Project Title: TLC Plumbing Co.

Re: **TLC Plumbing Office, Grading and Drainage Plan**
Engineer's Stamp dated 10-08-04 (G15-D62)

**Re: TLC Plumbing Office, 5030 Edith Blvd NE, Traffic Circulation Layout
Architect's Stamp undated (G15-D62)**

Re: TLC Plumbing Office, Traffic Circulation Layout (G15-D62)

SITE PLAN & TRAFFIC FLOW DIAGRAM

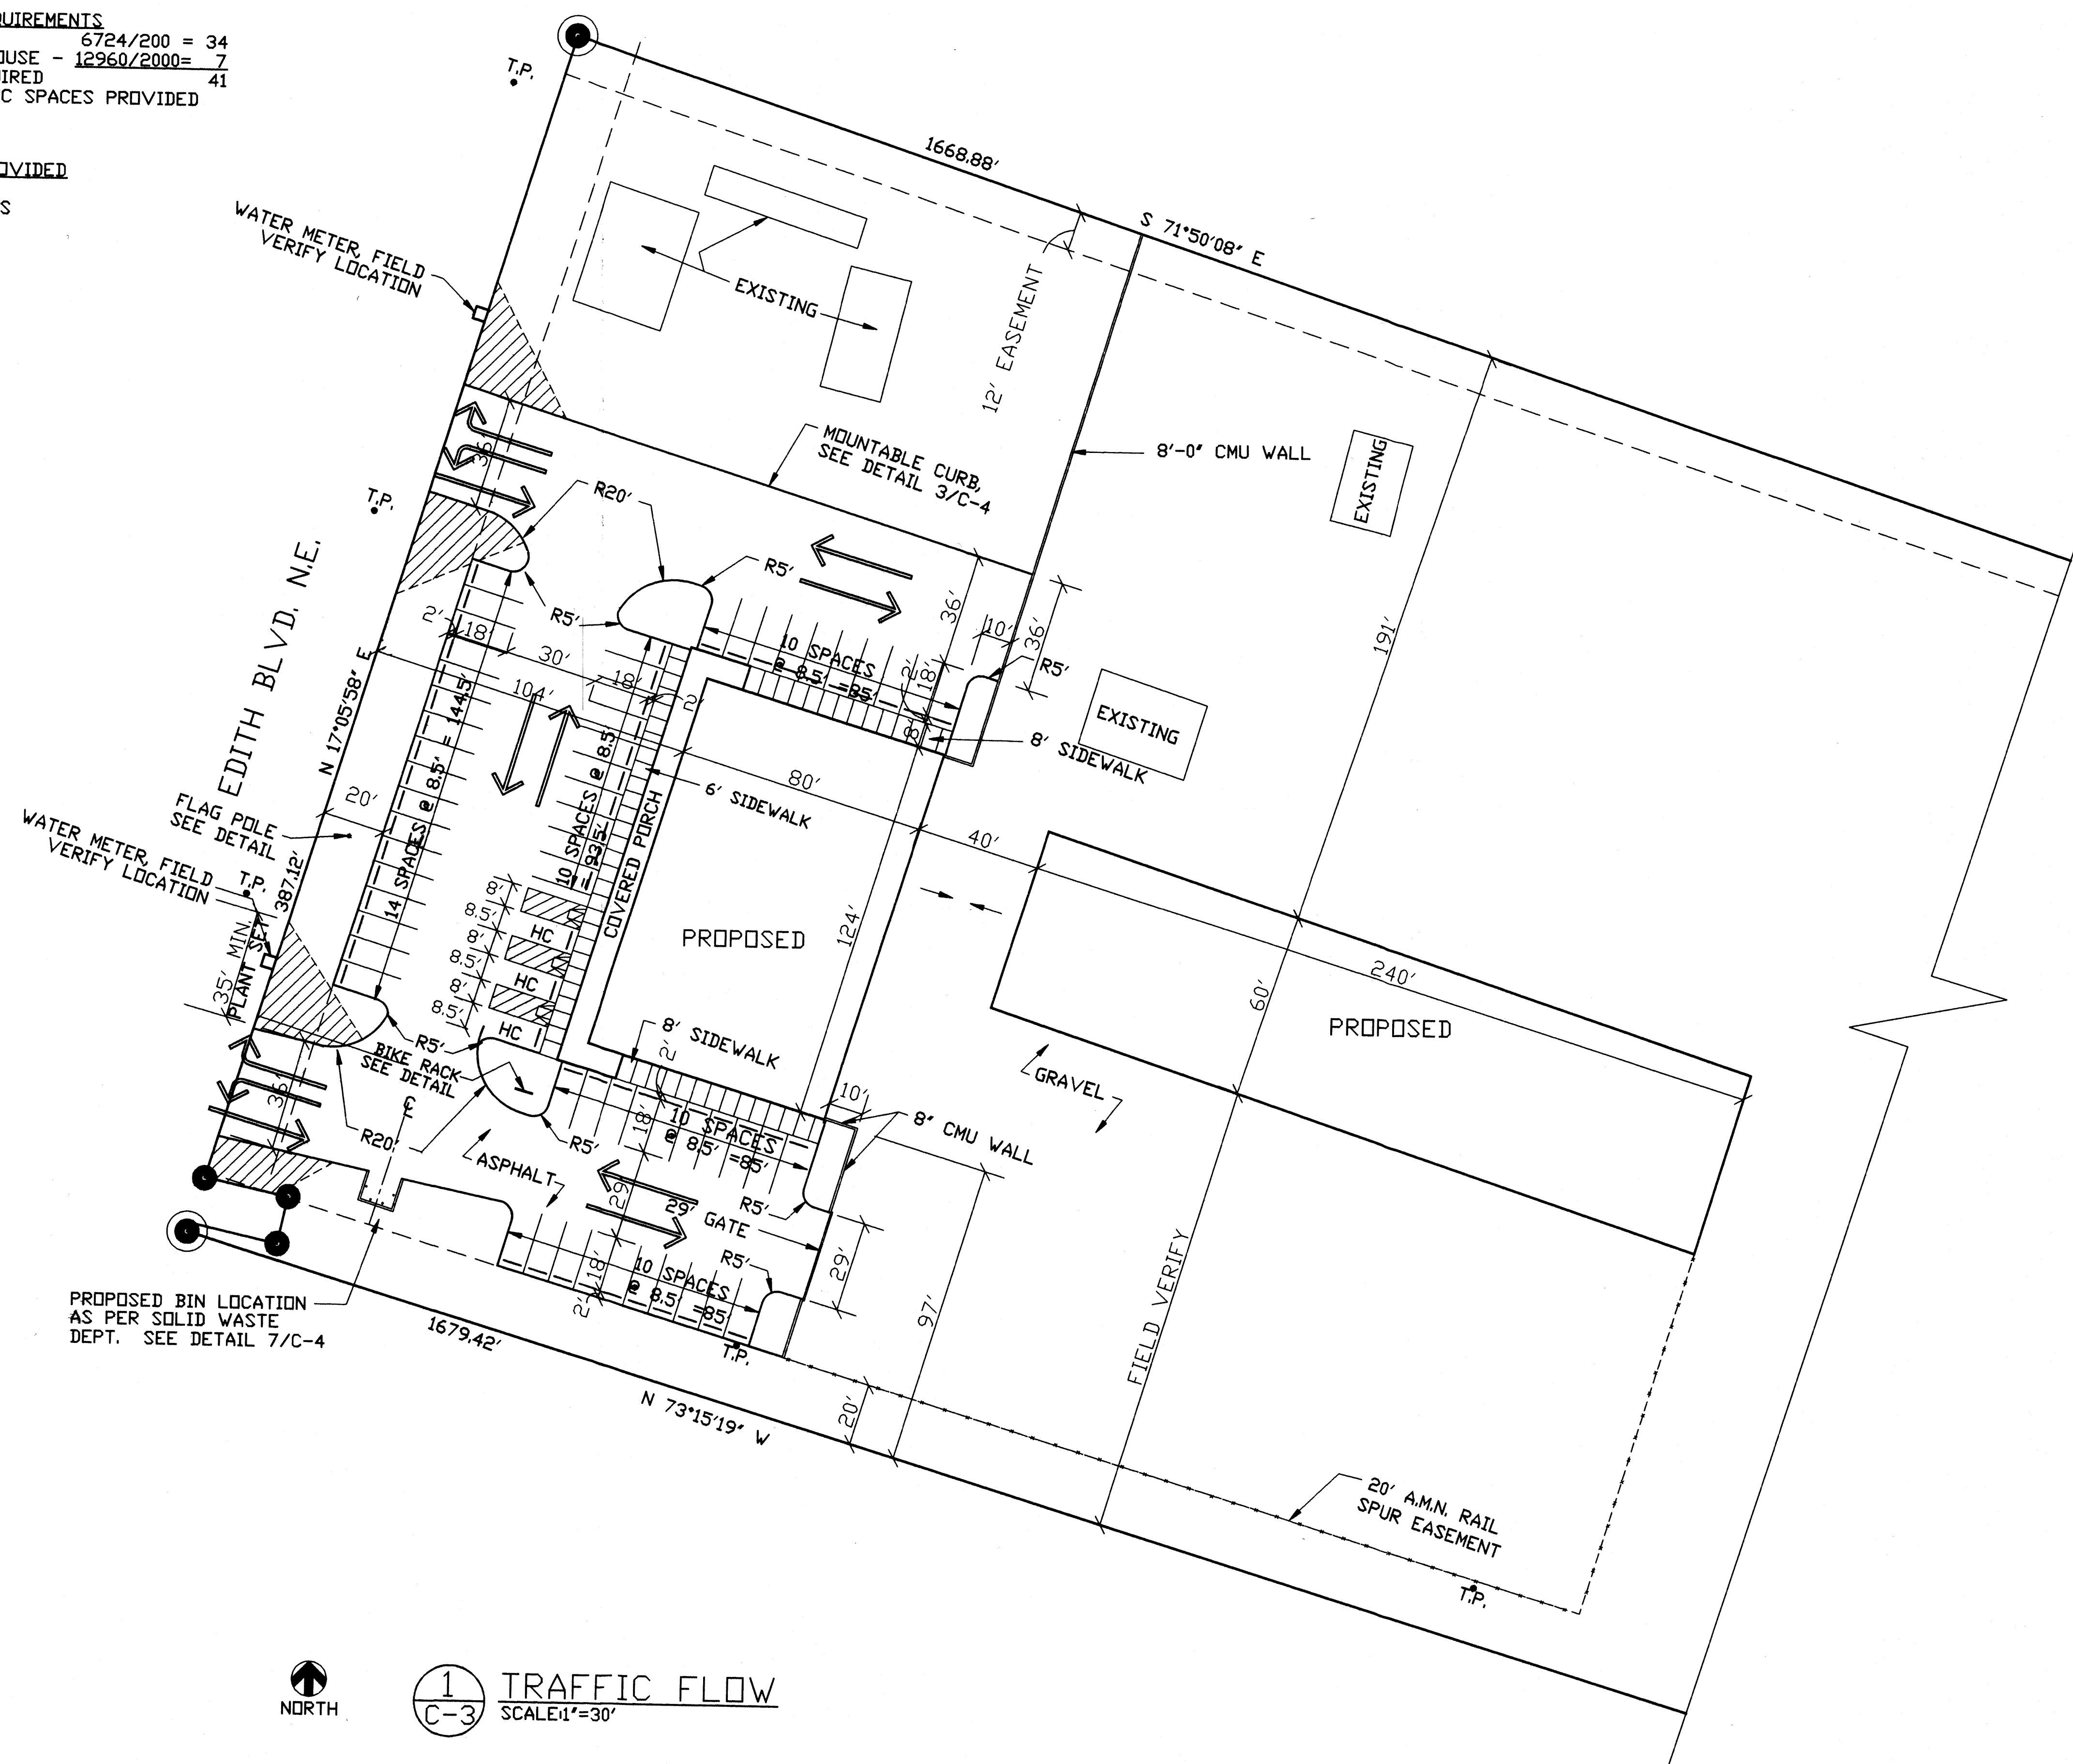
1. The handicapped spaces must include an 8-foot wide van access aisle; all other aisles should be 5 feet in width.
2. The architect's stamp should be dated, as well as stamped and signed, to help us track approved design sheets.
3. Define the width of all proposed sidewalk.
4. Call out the width of all proposed keyways. Please note that a five-foot paved keyway is required for deadend parking aisles.
5. Please note that the 2-foot overhang is not allowed to encroach on the 6 foot required width of sidewalk. Also, all standard parking spaces have a minimum length of 18 feet. Therefore, the sidewalk can be 8 feet wide with a 2-foot overhang, or the parking spaces must be 20 feet in length with bumpers.
